Re Planning Application No 2023 / 91212 Land off Bankfield Drive, Holmbridge

Our clients are concerned regarding several aspects of the development proposals and have requested Ashton Bennett to assess the documents available on the planning portal and comment on their behalf.

TITLE
S104 DRAINAGE LAYOUT PLAN

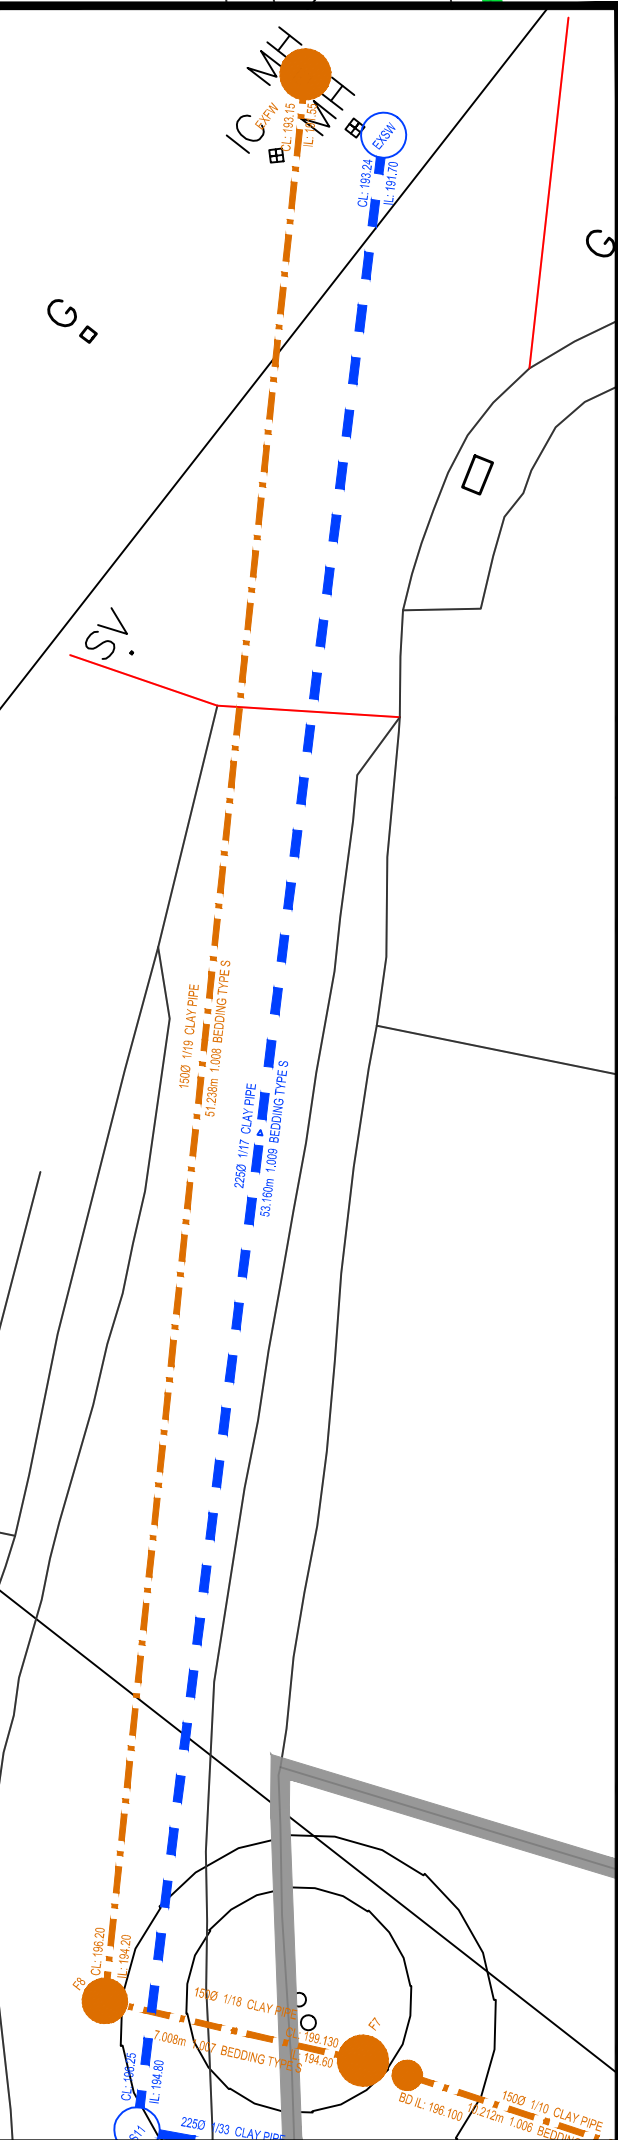
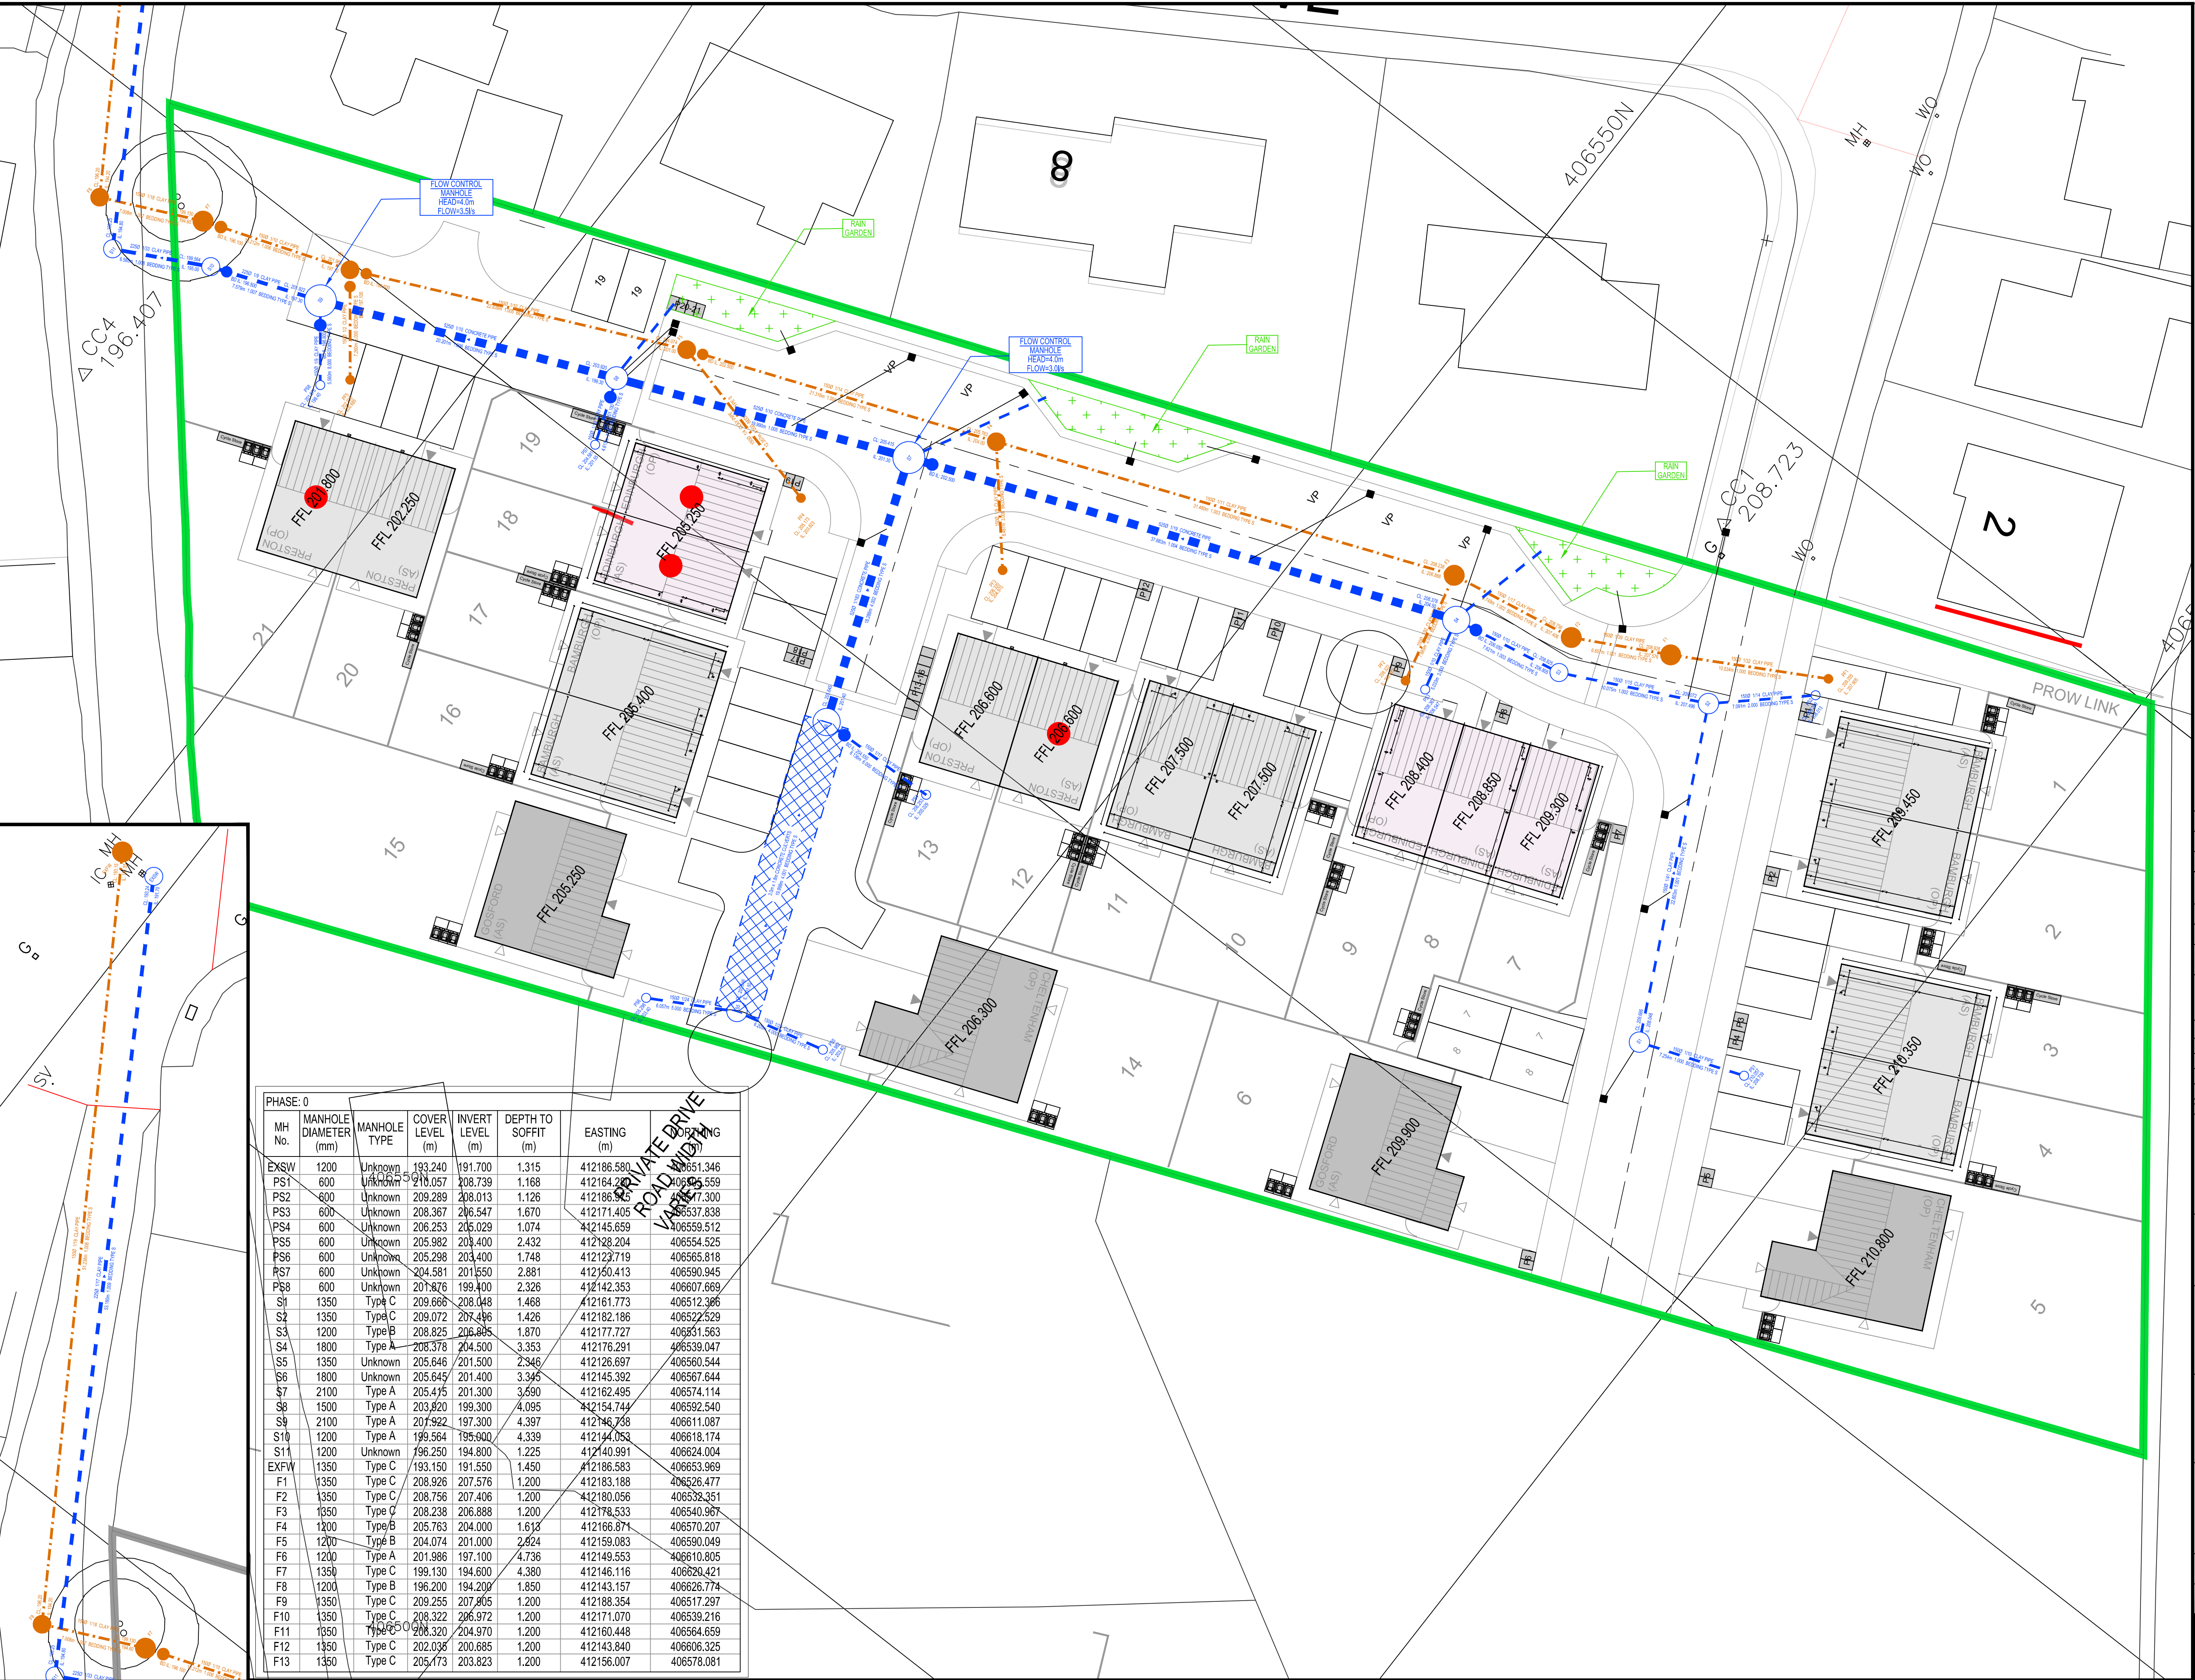
It is imperative that soakaways are not allowed on the site and that all surface water from the roofs and hard cover is sent to attenuation tanks and drained through the main drains.
